Consultation Response from: KC Environmental Health (Pollution & Noise Control)
2020/93308 Former Spotted Cow Pub, New Hey Road, Huddersfield HD3 4BU
Erection of foodstore (Use Class E) with associated parking, servicing areas and landscaping

Date Responded: 10 December 2020	Responding Officer: Mohammed Nasim (Noise) Rebecca Muff (Air Quality) Natalie Heaney (Contaminated Land) Richard Hume	Responding Ref: WK/202030347
---	--	---

drawing title
Proposed Lighting Plan

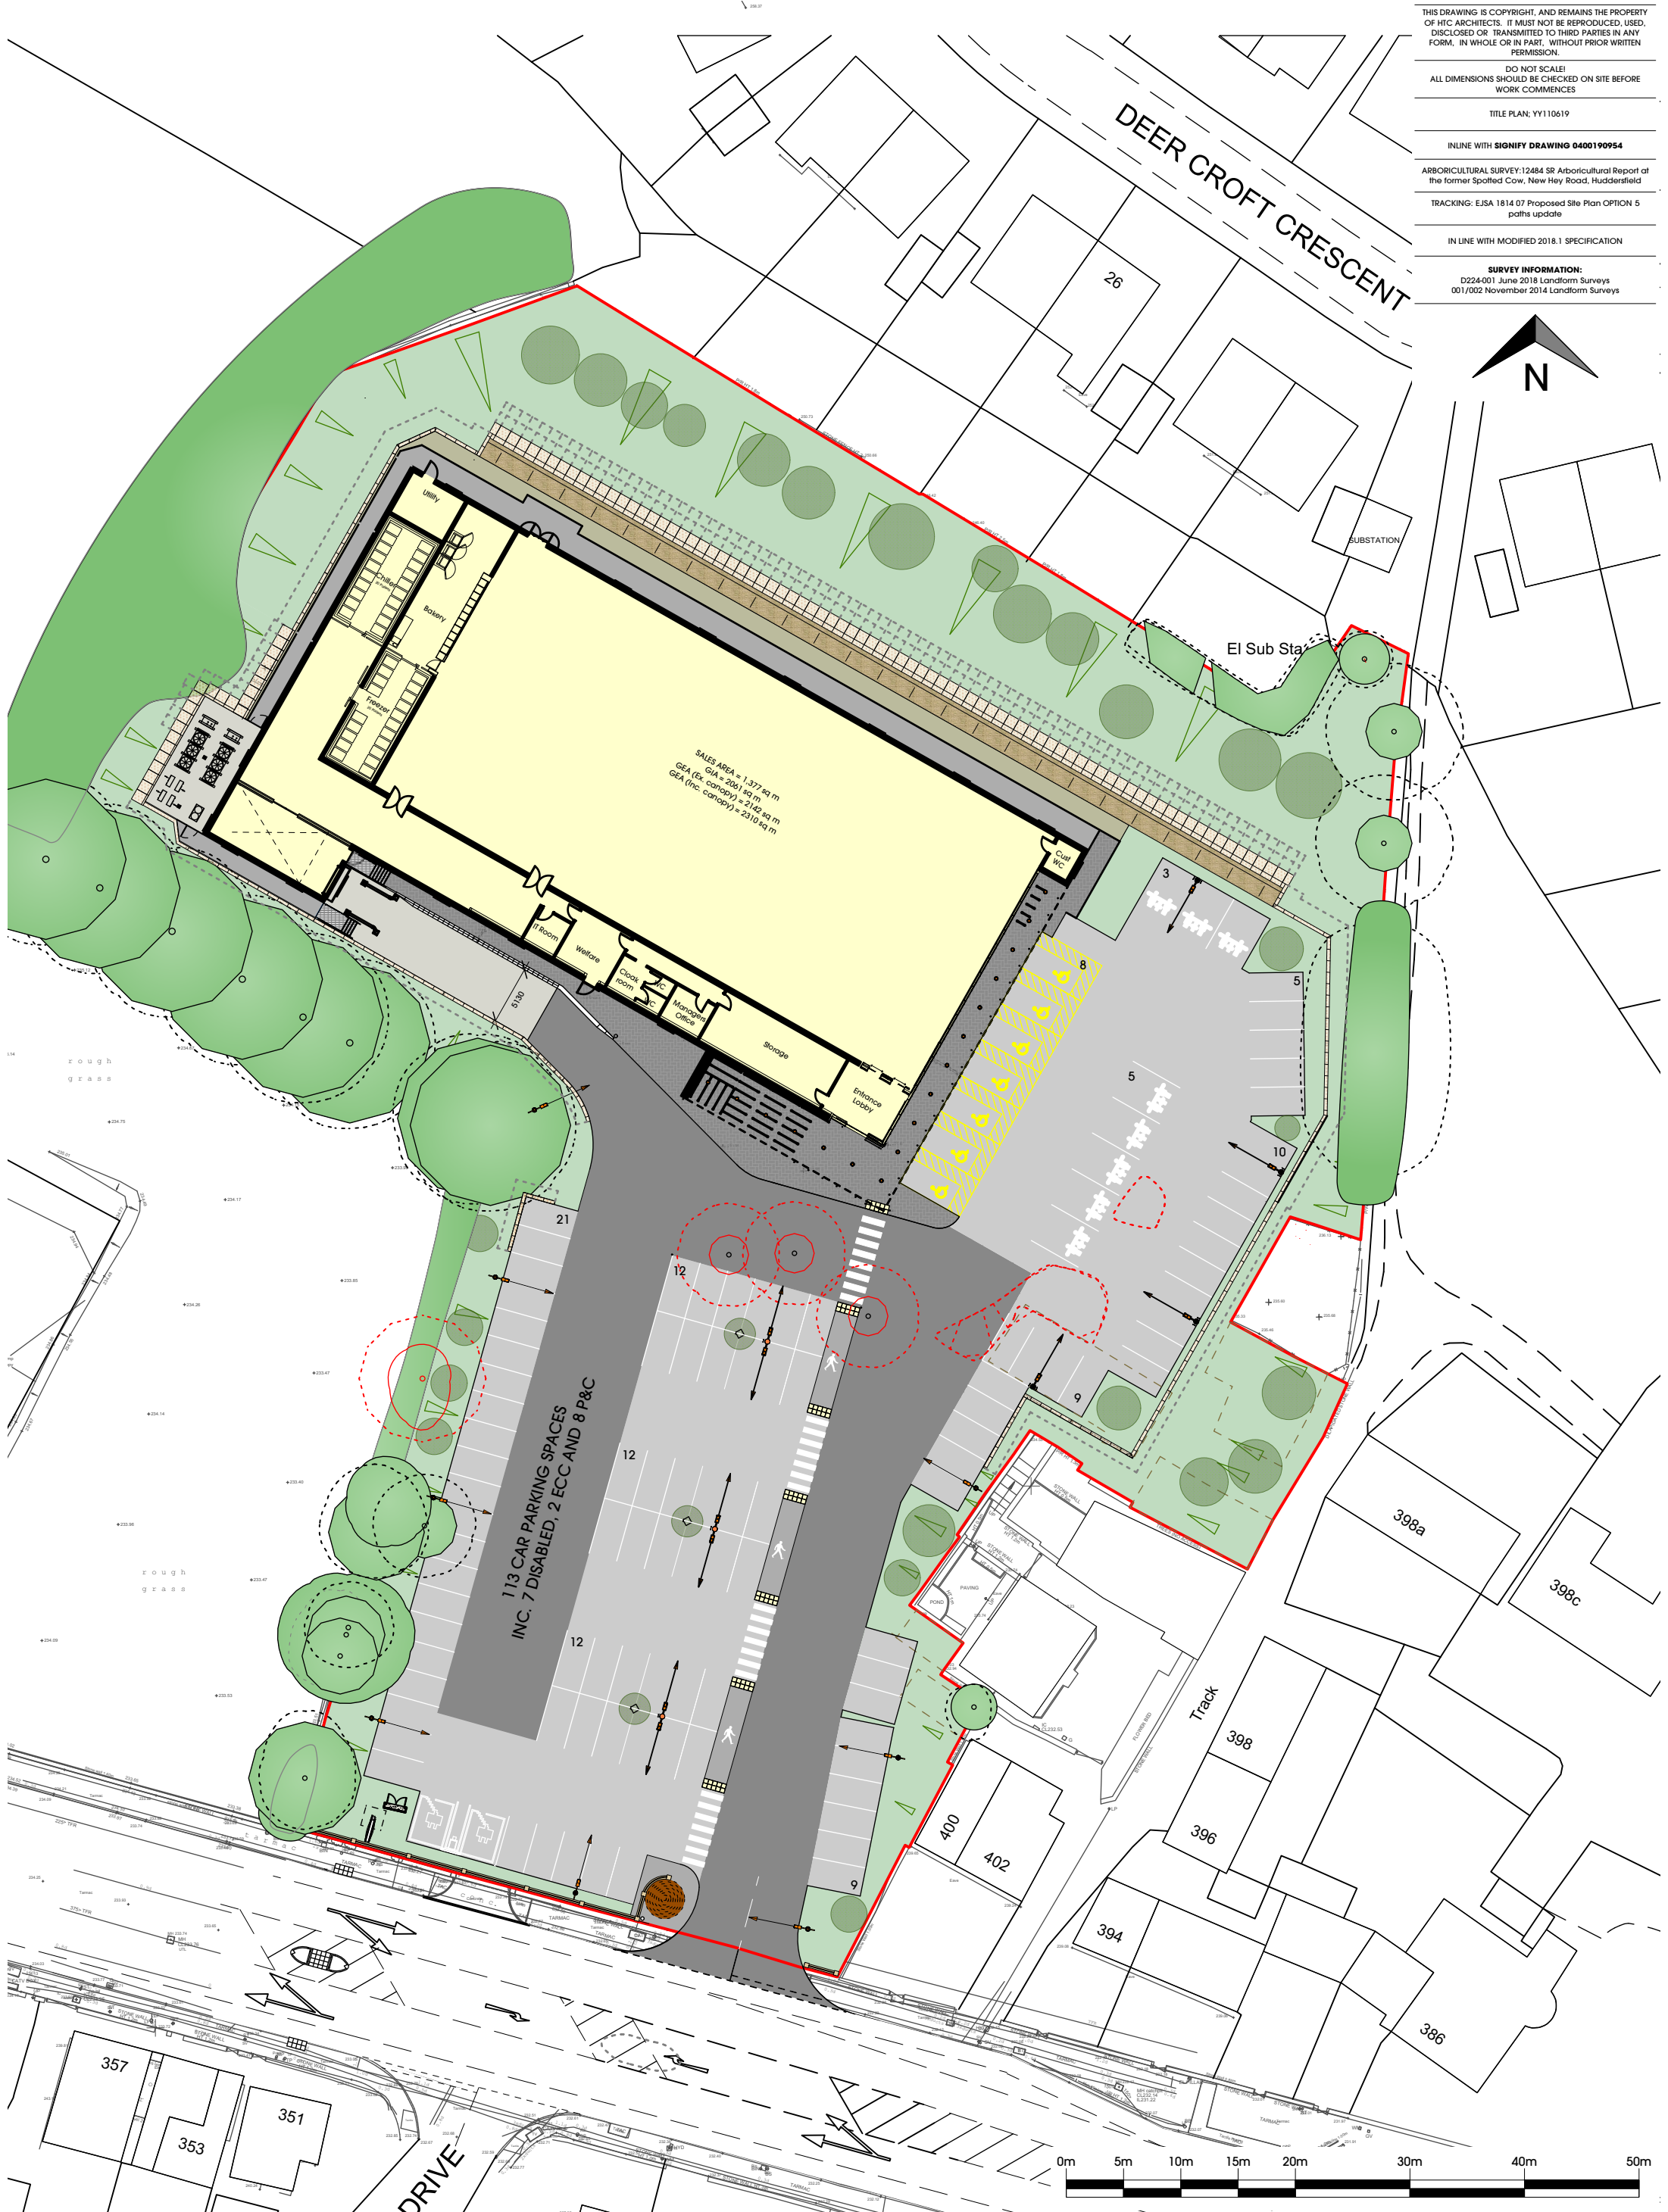
A lighting report by Signify (Project no. D-372174) dated 25.09.2020 has been submitted on behalf of Lidl in support of the application. The report details the proposed lighting scheme across the development site including the car park, lorry bay, and footpaths. The proposed development would appear to be in Environmental Zone E3 (suburban) – an area of medium district lighting. The predicted illuminance for each of the areas is summarised below:

- car park the maintained average illuminance is 14.1 lx
- lorry bay the maintained average illuminance is 23.7 lx
- foot path the maintained average illuminance is 5.7 lx

The vertical spill light diagrams for the car park show the extent of the illuminance beyond the site boundary. Both diagrams indicate an illuminance of 5 lx or less at light sensitive facades of properties that boarder the carpark. Having reviewed the report the lighting scheme appears to be acceptable. A condition will be necessary to require the external lighting to be installed as proposed to ensure adequate control the impact that the external lighting scheme will have on the amenity of the neighbouring properties.

Before the development is brought into use the external artificial lighting scheme shall be installed in accordance with those detailed in the lighting report by Signify (project no. D-372174) dated 25. 09. 2020. The external artificial lighting shall be installed and operated thereafter in accordance with the approved scheme.
